DRB Project Case #: 1005517

Subdivision Name: ENVIRCO TRACT TRACT B LOTS 2A1 & 2A2

**RE: JEFFERSON & OSUNA
SITE DEVELOPMENT PLAN FOR SUBDIVISION
CONDITIONS OF APPROVAL-15 EPC-40021**

Project# 1005517
15EPC-40021 Site Development Plan for Subdivision

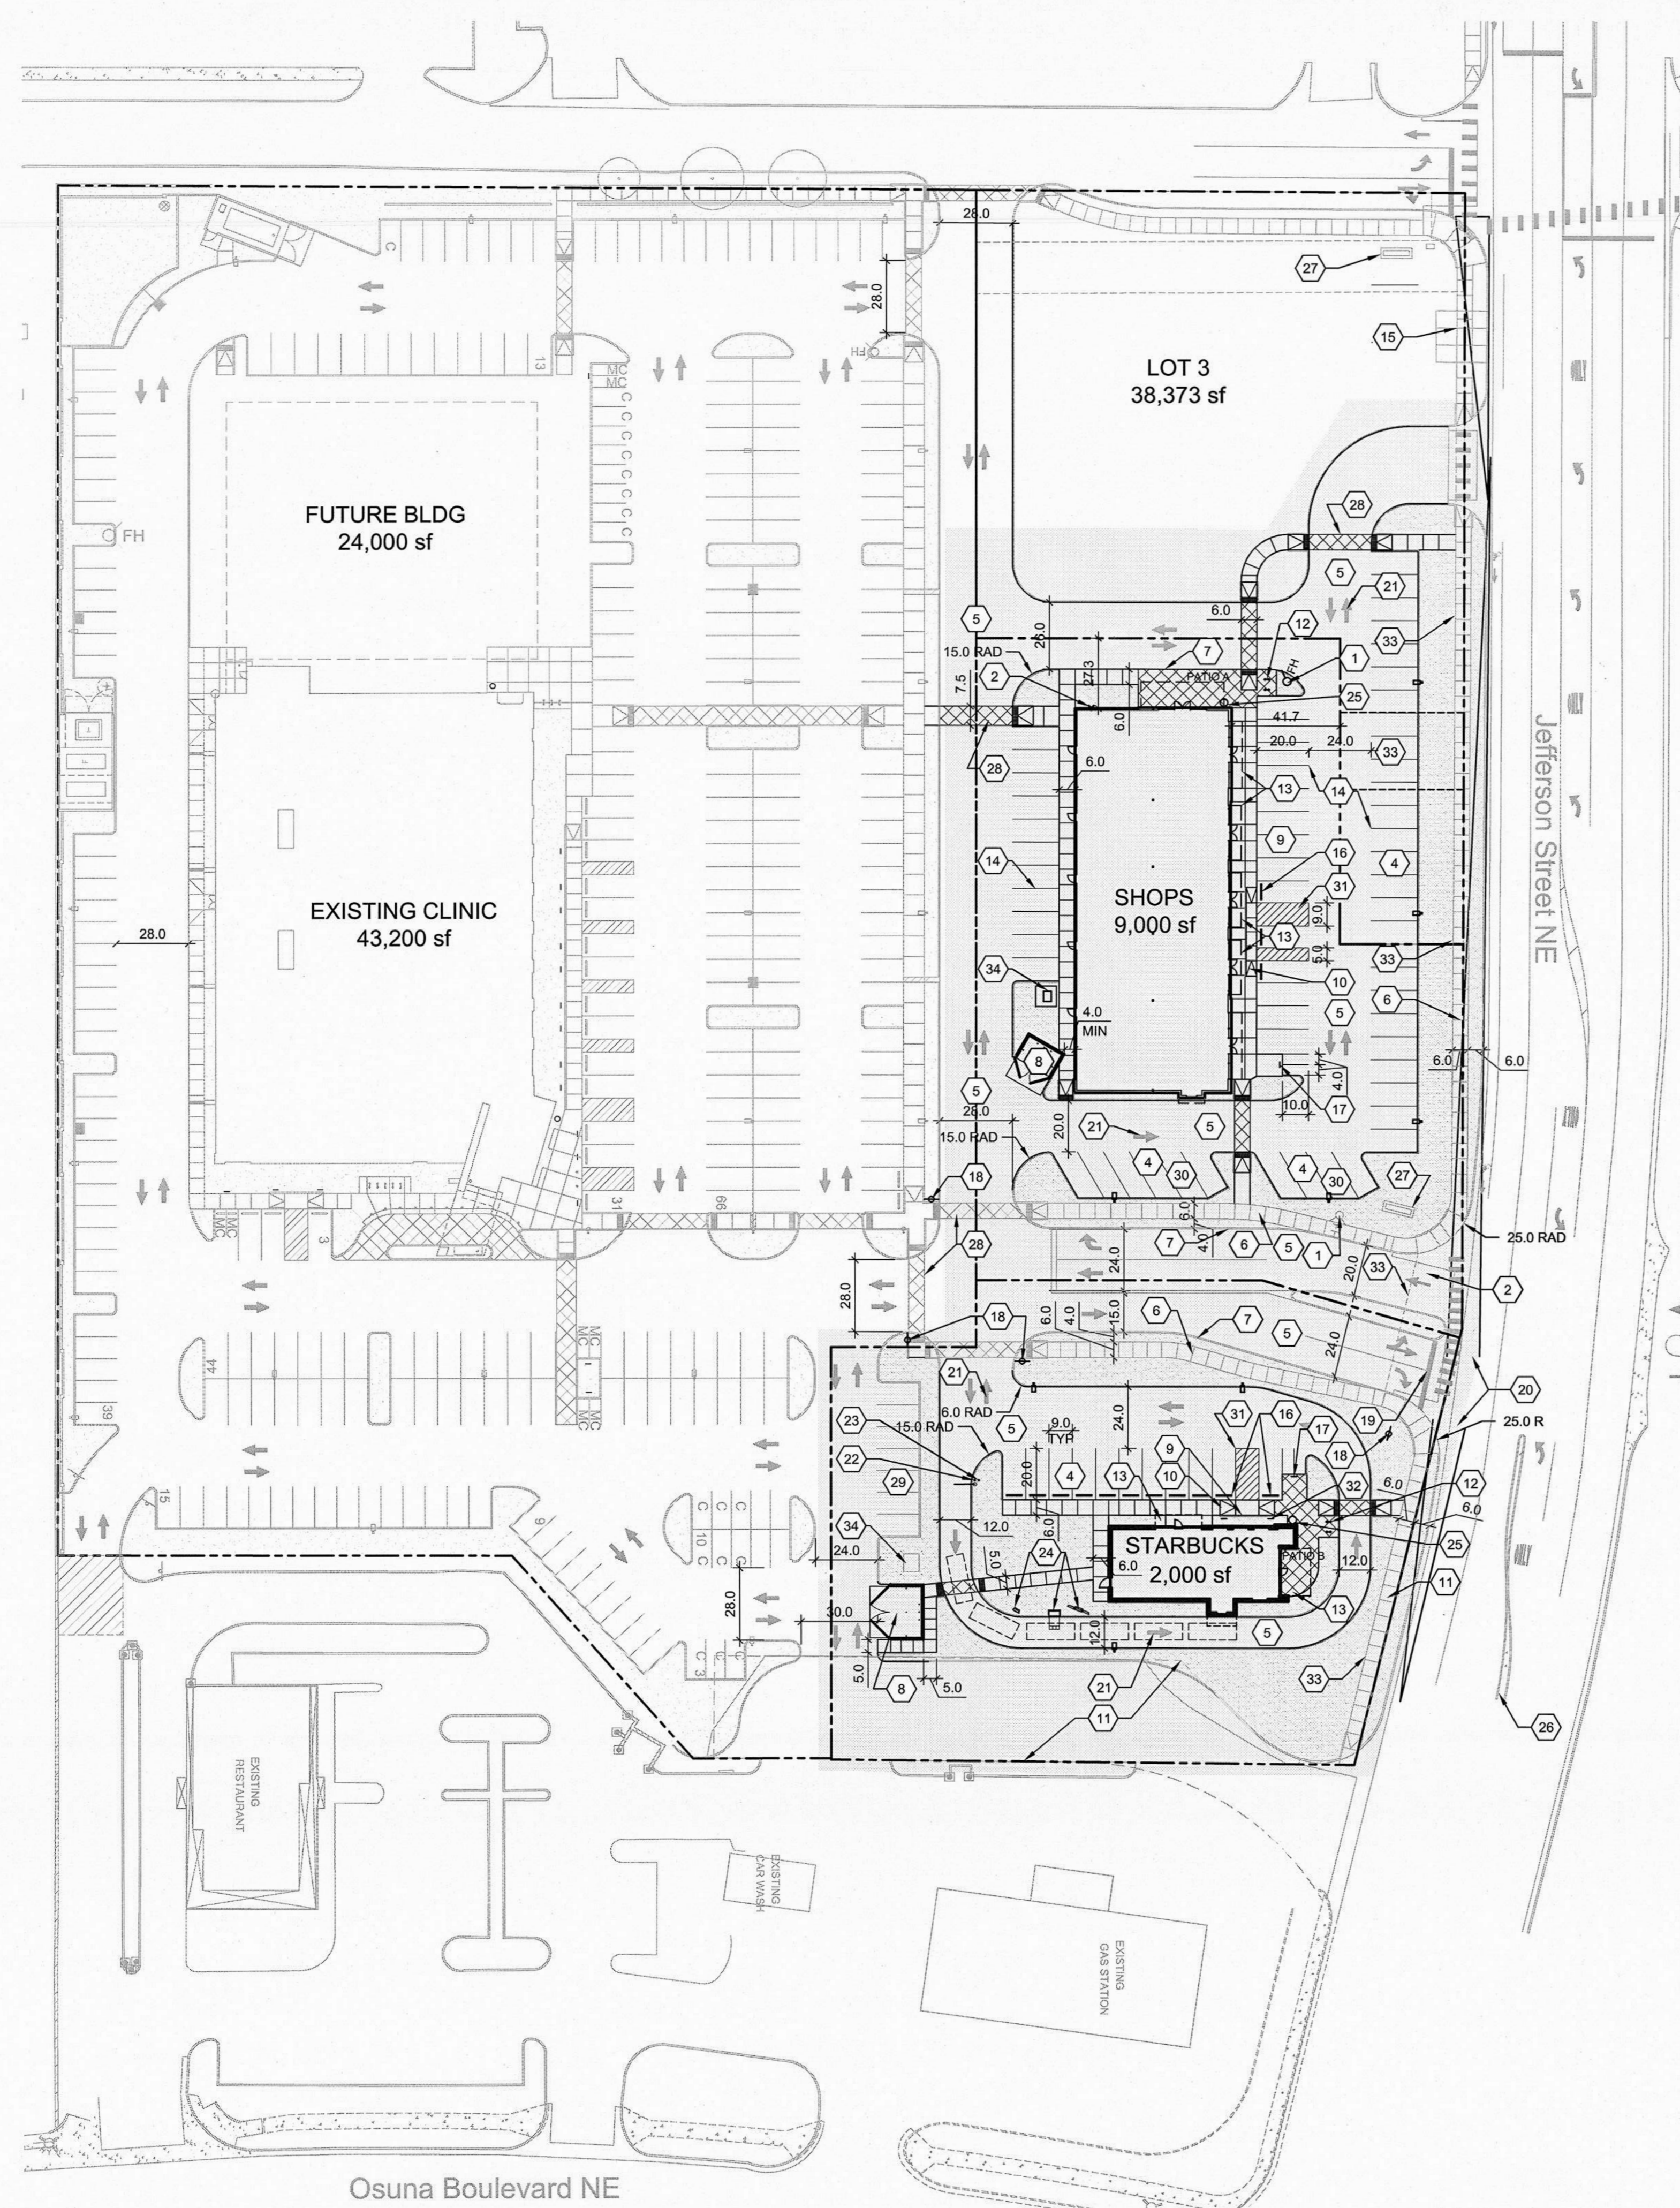
4. Site Development Plan for Subdivision:
The monument sign proposed along the private drive, on the subject site's northern side, shall be removed because it is not allowed pursuant to Zoning Code 14-16-3-2, Shopping Center Regulations.

- C. Show existing sidewalk facilities on Osuna and on Jefferson. Label existing driveway width for the westernmost driveway onto Osuna Road. Also, show all three existing driveways and respective driveway widths off of Osuna Road that are being utilized by the proposed development as indicated in the Traffic Impact Study dated May 28, 2015.

The sign along the private drive was removed from the plan as shown on the Site Development Plan.

Existing sidewalk facilities on Osuna & Jefferson and existing drives with respective widths on Osuna were added to the Site Plan for Subdivision (see attached redlines).
